CITY OF ALBUQUERQUE

August 24, 2012

**Re: Sevano Point Subdivision
Grading and Drainage Plan
Engineer's Stamp Date 07/31/2012 (C18/D075)**

CITY OF ALBUQUERQUE PUBLIC WORKS DEPARTMENT ENGINEERING GROUP			
TITLE: CONCEPTUAL		SEVAND POINT GRADING AND DRAINAGE PLAN	
DESIGN REVIEW COMMITTEE	CITY ENGINEER APPROVAL	LAST DESIGN DATE	MO./DAY/YR. MO./DAY/YR.
PROJECT NO.	MAP NO. C-18	SHEET 2	OF 2

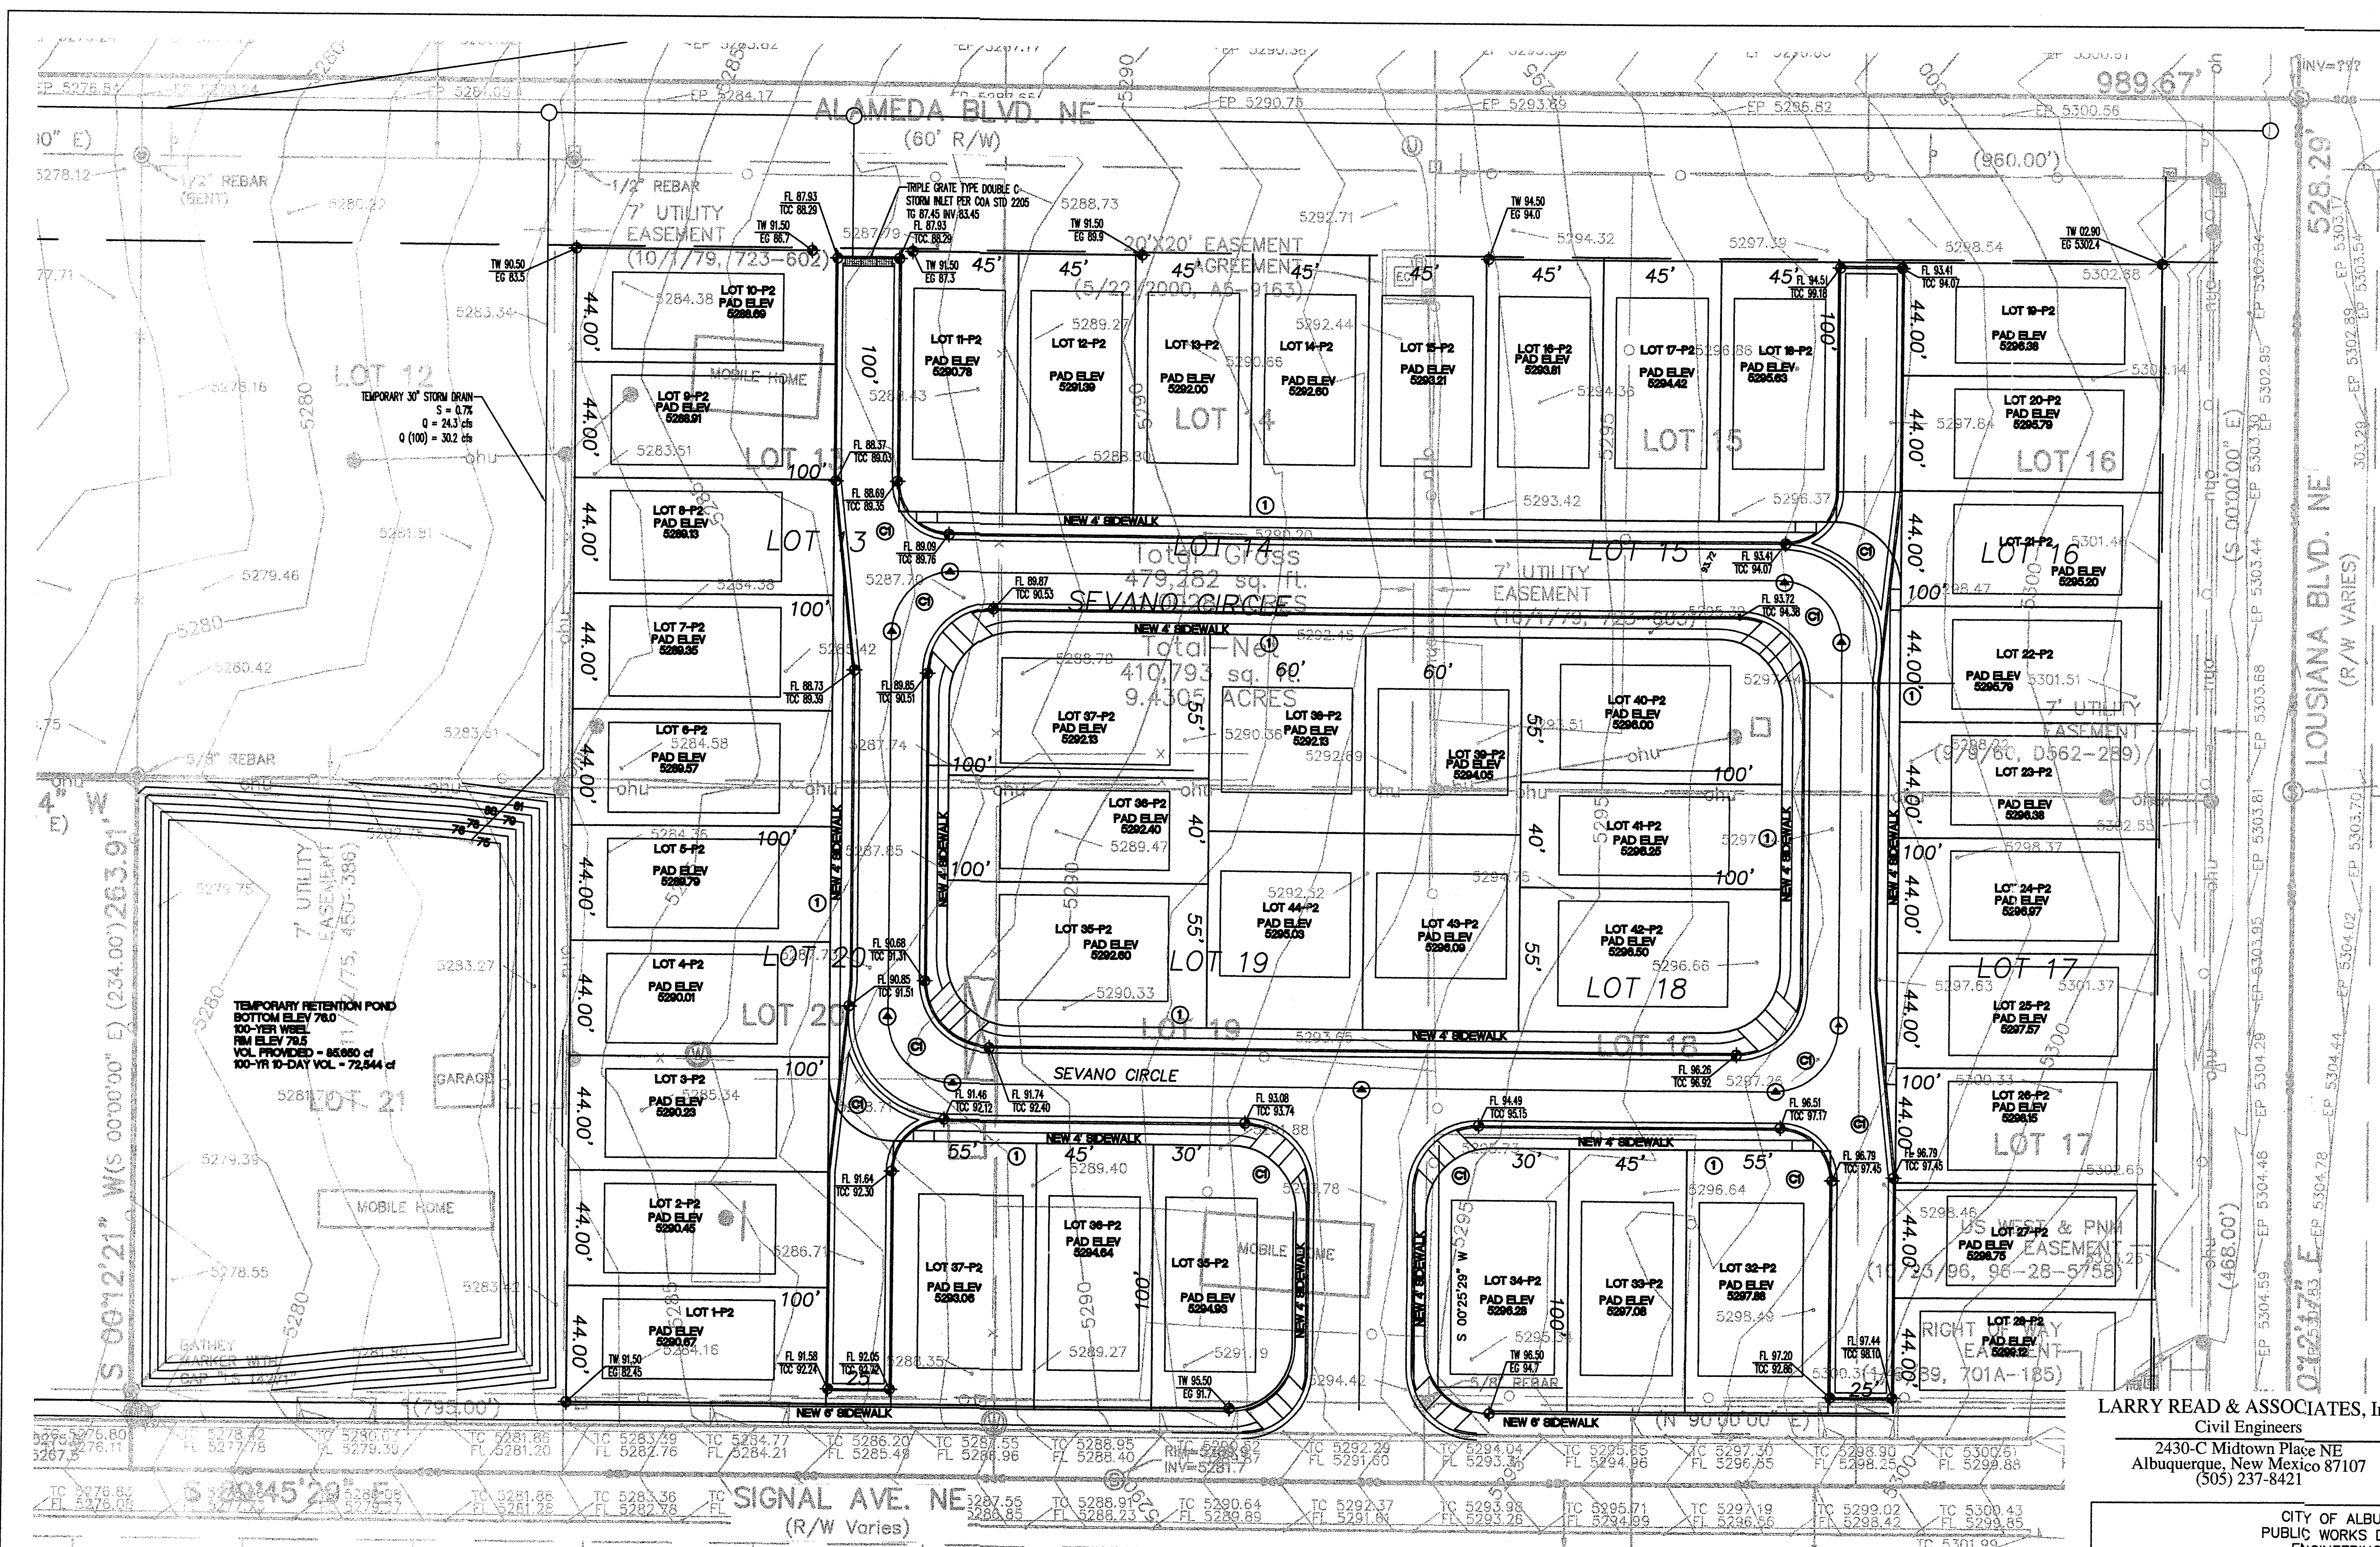
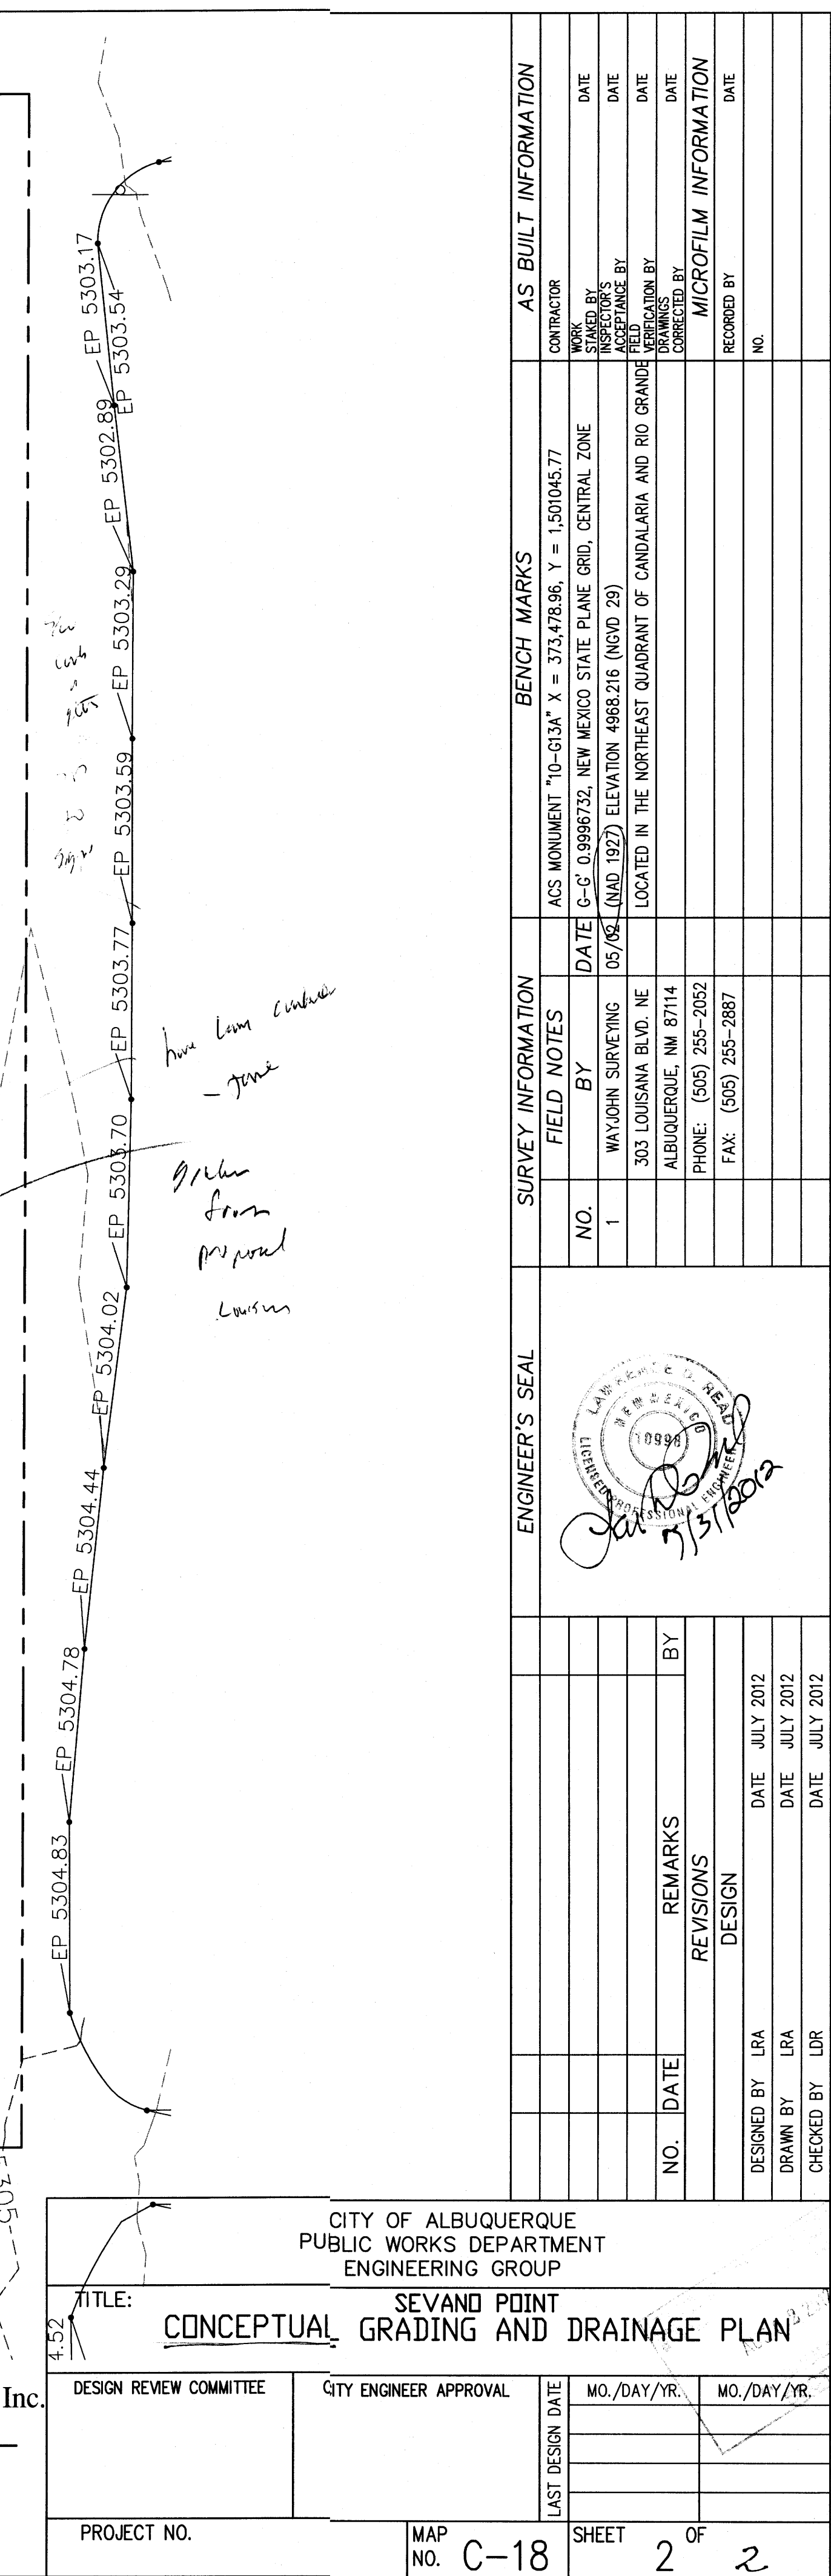
- Clearly show proposed and existing retaining walls.
- Runoff shown on the plan exceeds the allowable runoff from the North Albuquerque Acres Master Drainage Plan.

- If Alameda storm drain system is not built at the time this project is being constructed you are proposing to drain the northerly portion of this site to an existing retention pond west of the existing church. Do you have an authorization from the property owner to drain to this pond?

- Use storm drain pipe to drain the northerly basin. Please coordinate with City of Albuquerque for the storm drain connection into Alameda Storm Drain System.

- Use the entrance to drain the southerly basin to Signal Avenue. We suggest that the entrance would be moved to the west.
- Please provide copies of the proposed plat and infrastructure list.
